Final Acceptance Punch List

Date: 3/21/2024
Subdivision: Hannah Ridge at Feathergrass Filing No. 5 & 6
EDARP File #: SF1838 & SF1839
Developer: Classic Homes Construction
Address: 6385 Corporate Dr. Ste. 200
Colorado Springs, Colorado 80919

Hannah Ridge at Feathergrass Filing No. 5 & 6

STREET ABBREVIATION INDEX:
 PCL PONY CLUB LANE
 BCW BREECHERS WAY
 ETD ELECTRONIC DRIVE

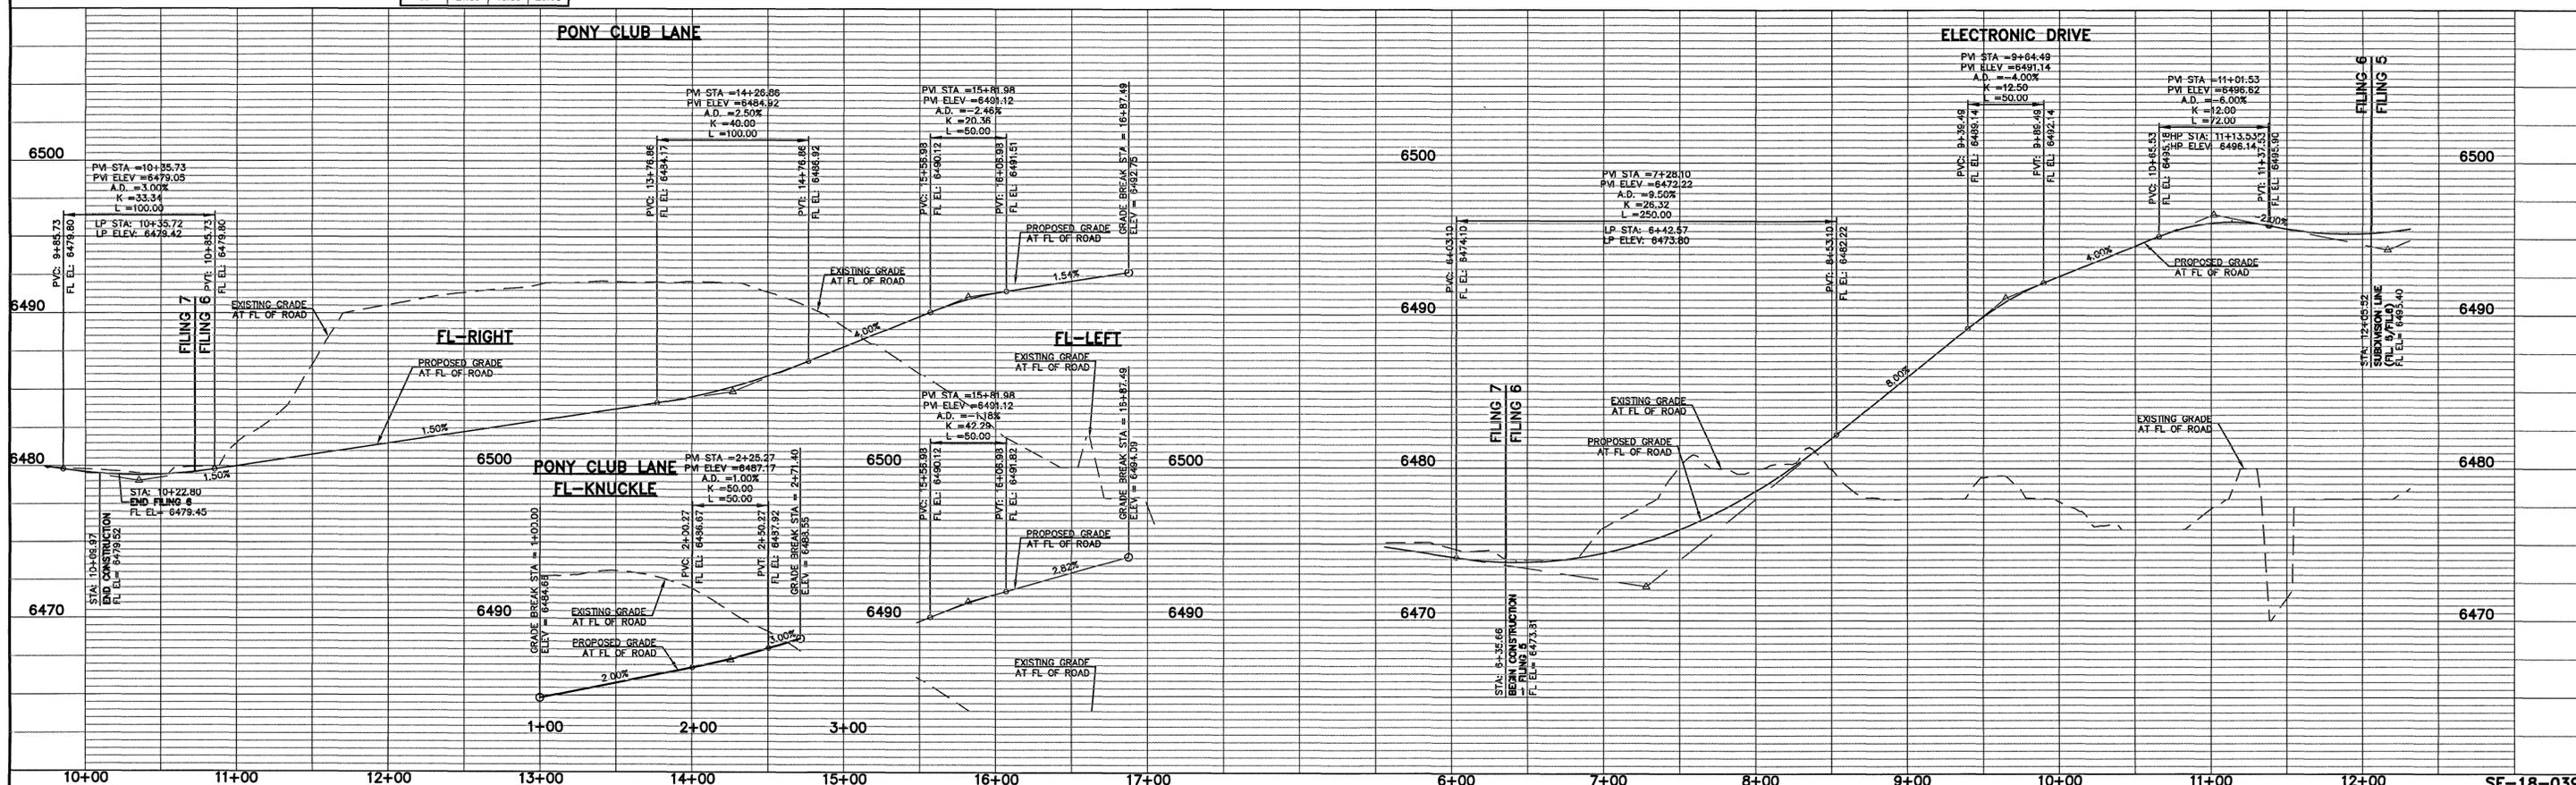
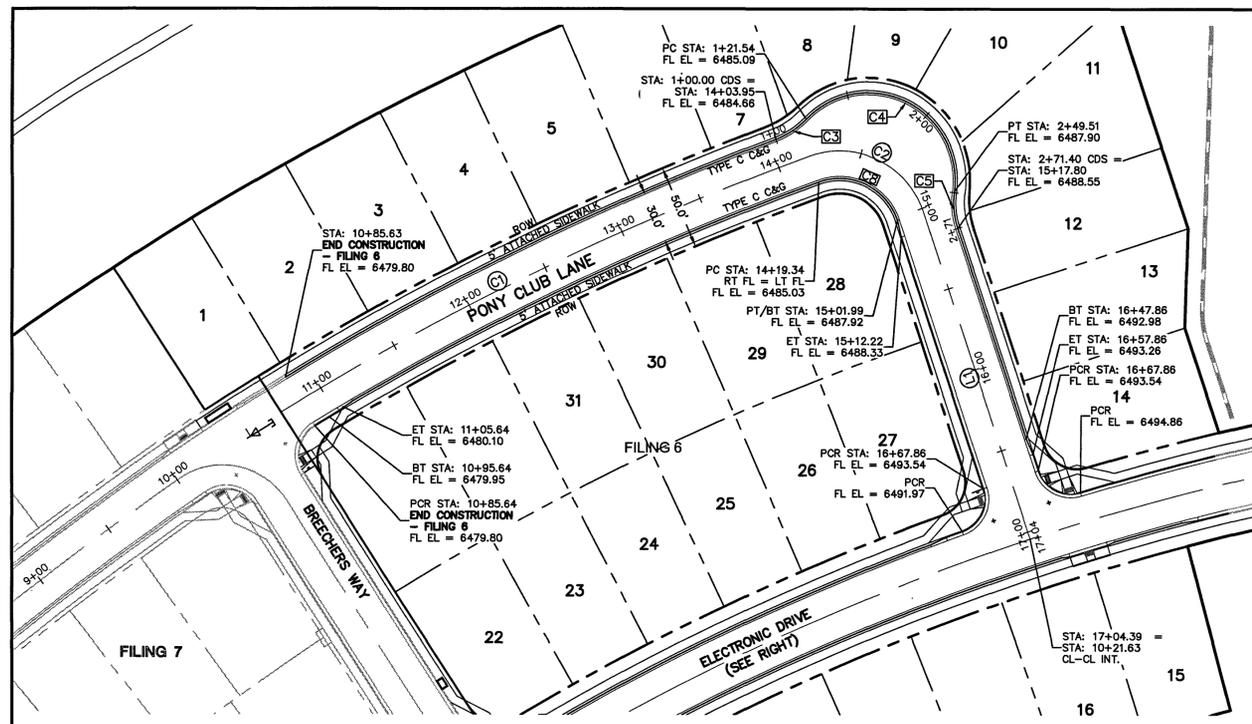
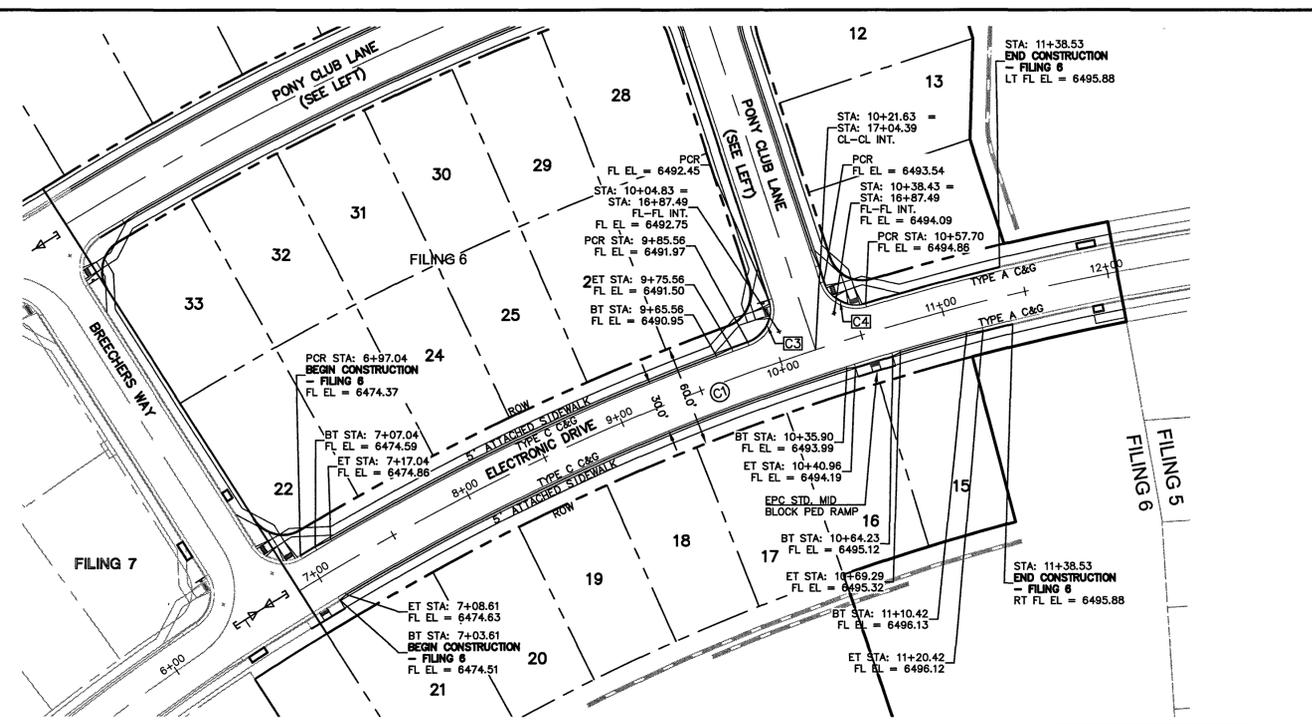
- Install missing road name sign on Electronic Drive.
- Caulk gap between sidewalk and curb/gutter from Electronic Dr. and Equine Ct. intersection going north up to 2922 Equine Ct.
- Remove and replace sidewalk stones x6 and curb and gutter x3 at 3020 Equine Ct. for settlement.
- Caulk gap between sidewalk and curb/gutter at the Equine Ct. cul-de-sac.
- General- Caulk between sidewalk and curb/gutter and crack seal asphalt as needed on Electronic Drive.
